Consultee Comment for planning application 22/02696/DISC

Application Number	<input type="text" value="22/02696/DISC"/>
Location	<input type="text" value="OS Parcels 3309 And 4319 Adjoining And North Of Milton Road Adderbury"/>
Proposal	<input type="text" value="Discharge of Conditions 3 (surface water drainage scheme), 6 (revised plan), 7 (landscaping scheme), 8 (site levels), 9 (surface water drainage scheme), 11 (turning area and parking spaces), 12 (boundary enclosures), 14 (public footpath) and 15 (covered cycle parking facilities) of 18/00220/F"/>
Case Officer	<input type="text" value="Michael Sackey"/>
Organisation	<input type="text" value="CDC - Land Drainage"/>
Name	<input type="text" value="Tony Brummell"/>
Address	<input type="text" value="Cherwell District Council Bodicote House White Post Road Bodicote Banbury OX15 4AA"/>
Type of Comment	<input type="text" value="Comment"/>
Type	<input type="text"/>
Comments	<input type="text" value="Phase 1

2. INPUT OF PERMEABILITY TEST DATA

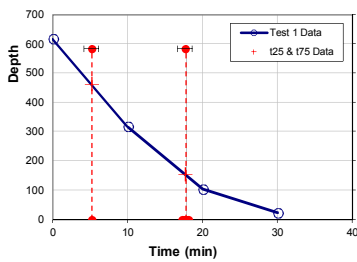
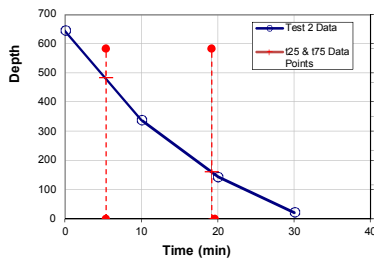
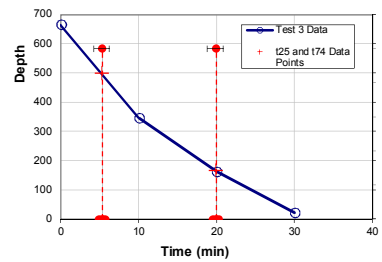
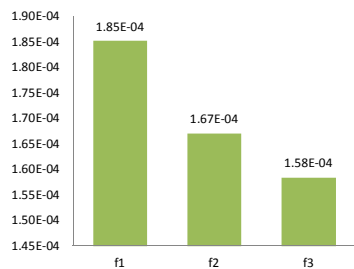
The surface water drainage strategy has been revised and now based on infiltration by means of a porous carrier pipe system beneath the sports pitch surface which has already been installed. The effectiveness of this means has been based on the porosity of the subsoil being <math>1.85 \times 10^{-4}</math> m/s, this reflecting the worst of the tests carried out at a single location near the north-west corner of the pitch. Subject to requiring the applicant to provide reasonable evidence that this porosity is representative of the whole pitch area, I am content to discharge the Condition.
